72 BISHOP STREET

Title:
SUBDIVISION PLAT
PLAN

SURVEY REVIEW 6/01/2015

Title:
LAYOUT AND LIGHTING PLAN

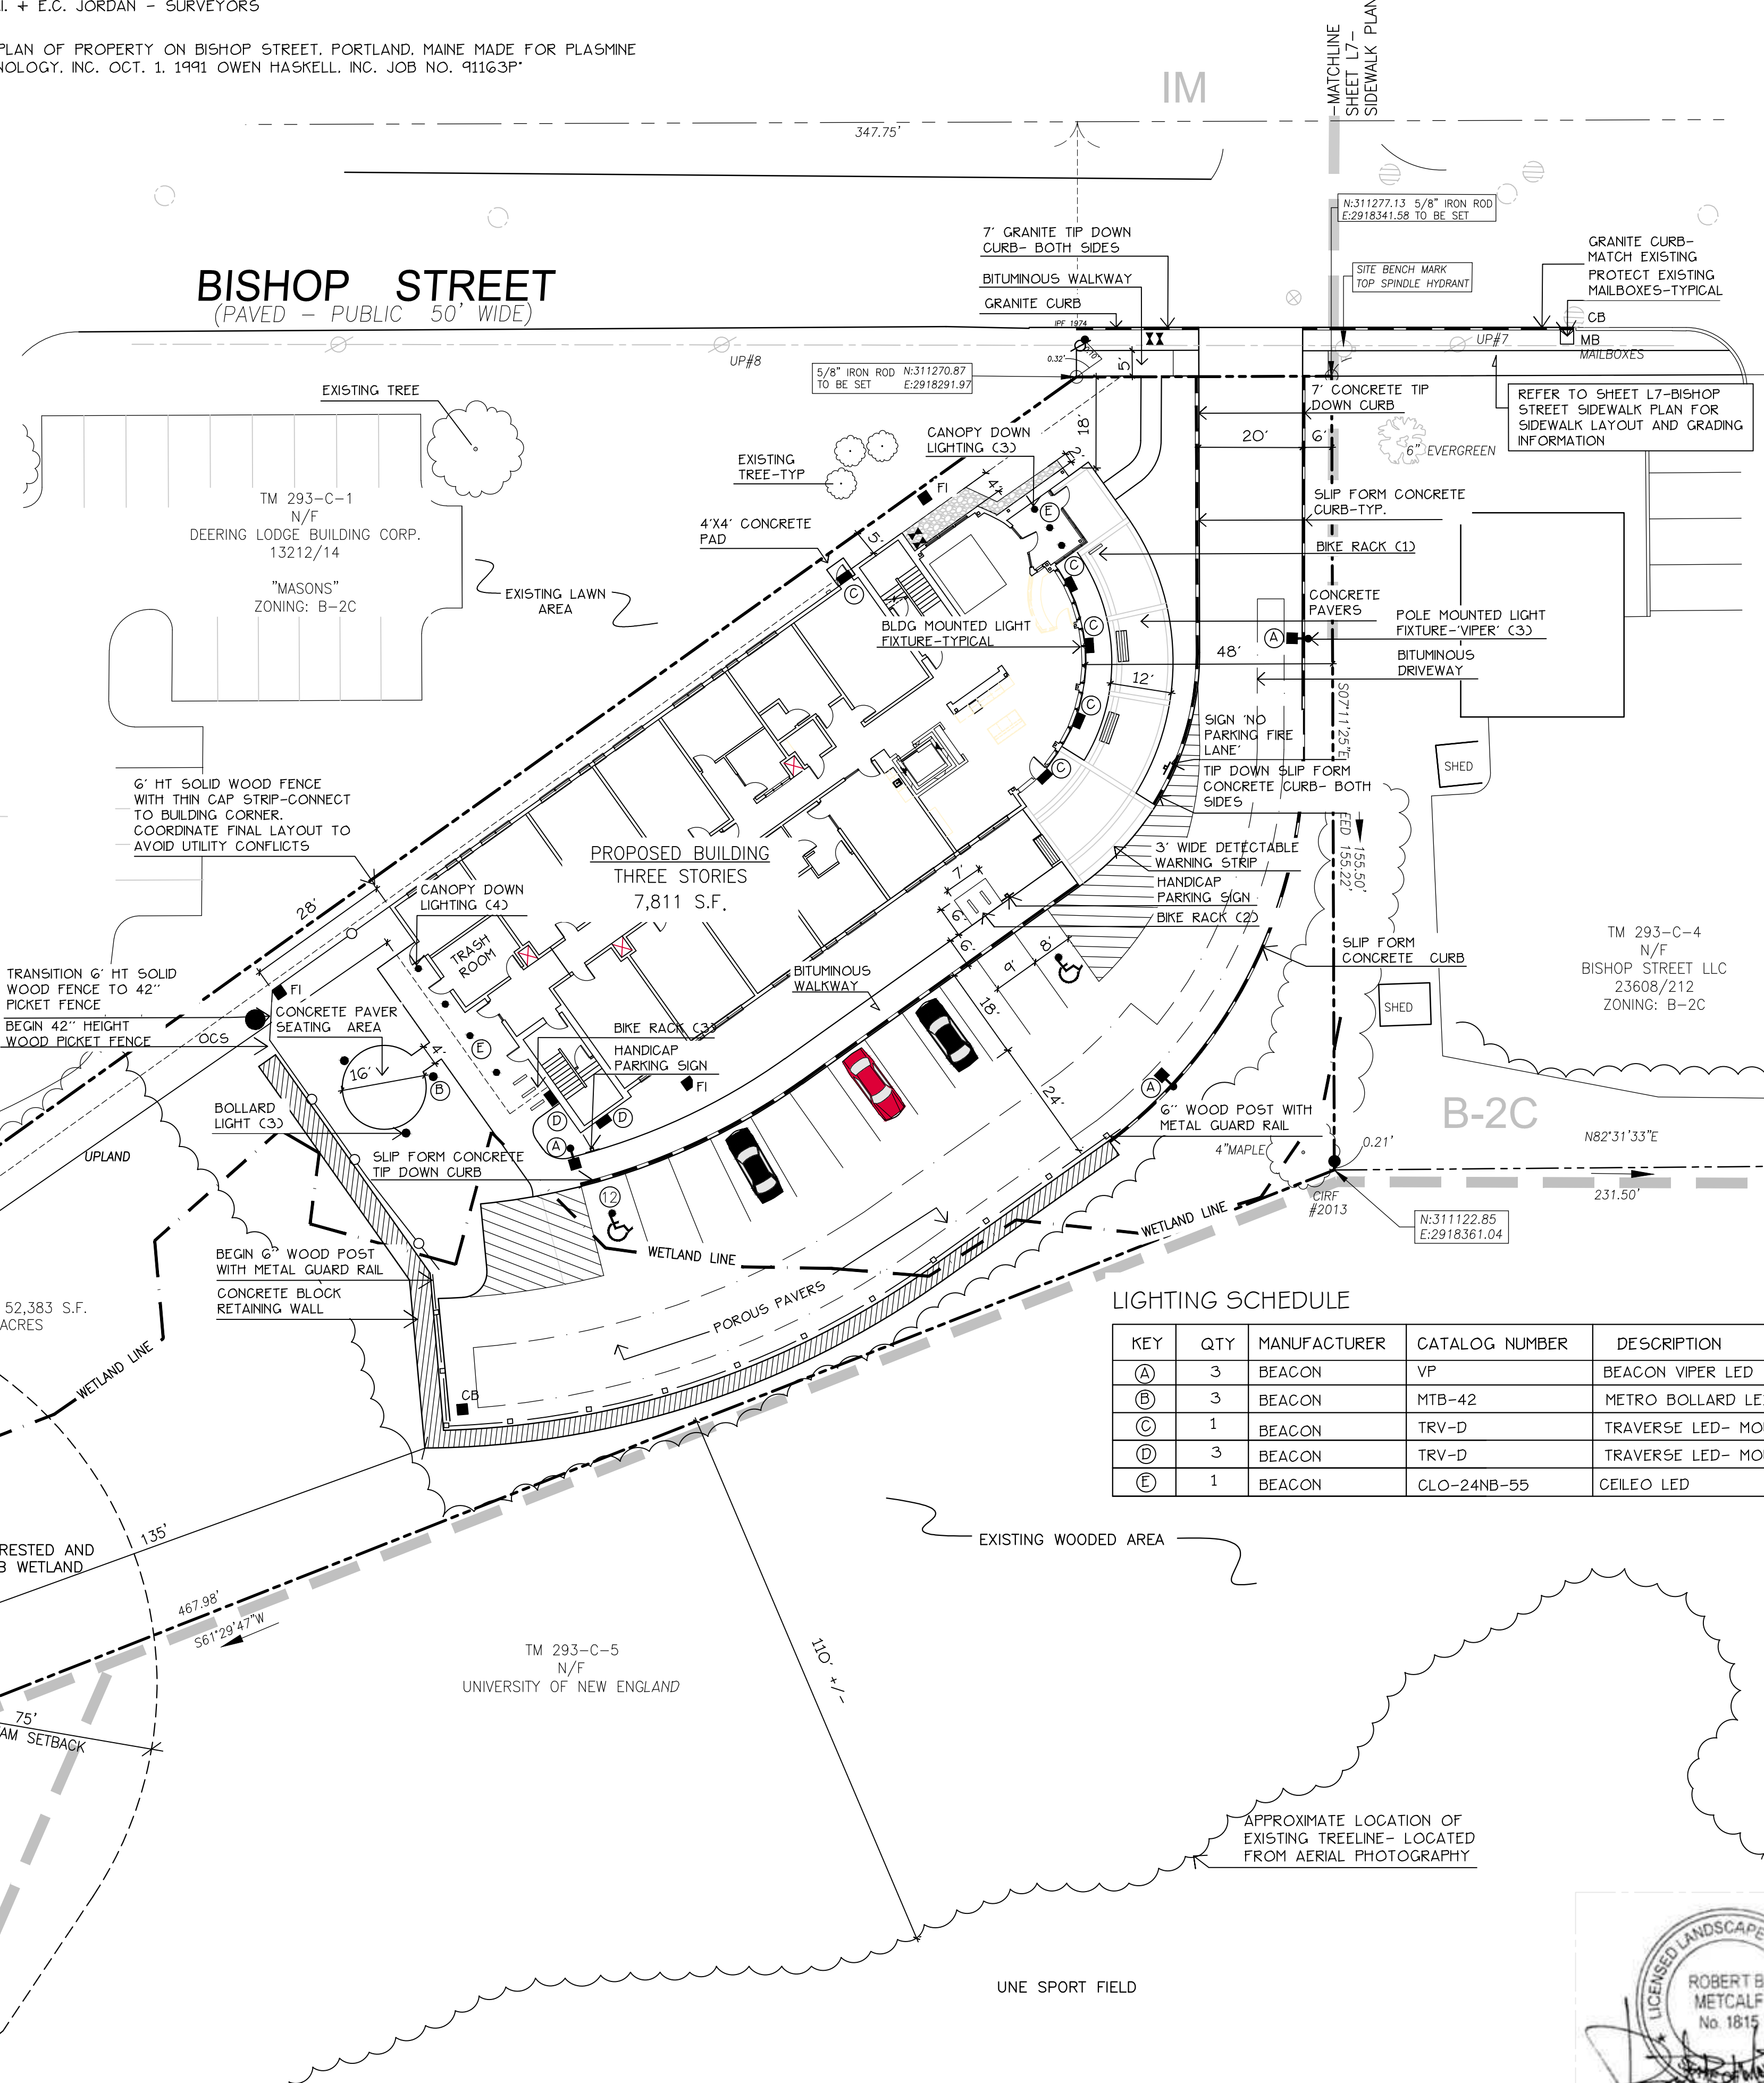
- EXISTING CONDITIONS AND BOUNDARY INFORMATION TAKEN FROM A PLAN ENTITLED 'BOUNDARY + TOPOGRAPHIC SURVEY AT 72 BISHOP STREET, PORTLAND, MAINE' PREPARED BY OWEN HASKELL, INC. DATED JULY 17, 2014. *NAVD83 - HAN, Maine State Plane, West Zone (Ears 1802) is City Horizontal*

- BEARINGS ARE GRID NORTH AND ELEVATIONS ARE NAVD83 AS BASED ON STATIC GPS COLLECTION AND OPUS CORRECTION. *NOT CORRECT CITY DATUM IS NGVD29. SITE TOP & PROPOSED GRADES & STRUCTURES NEED TO BE CORRECTED TO NGVD29.*
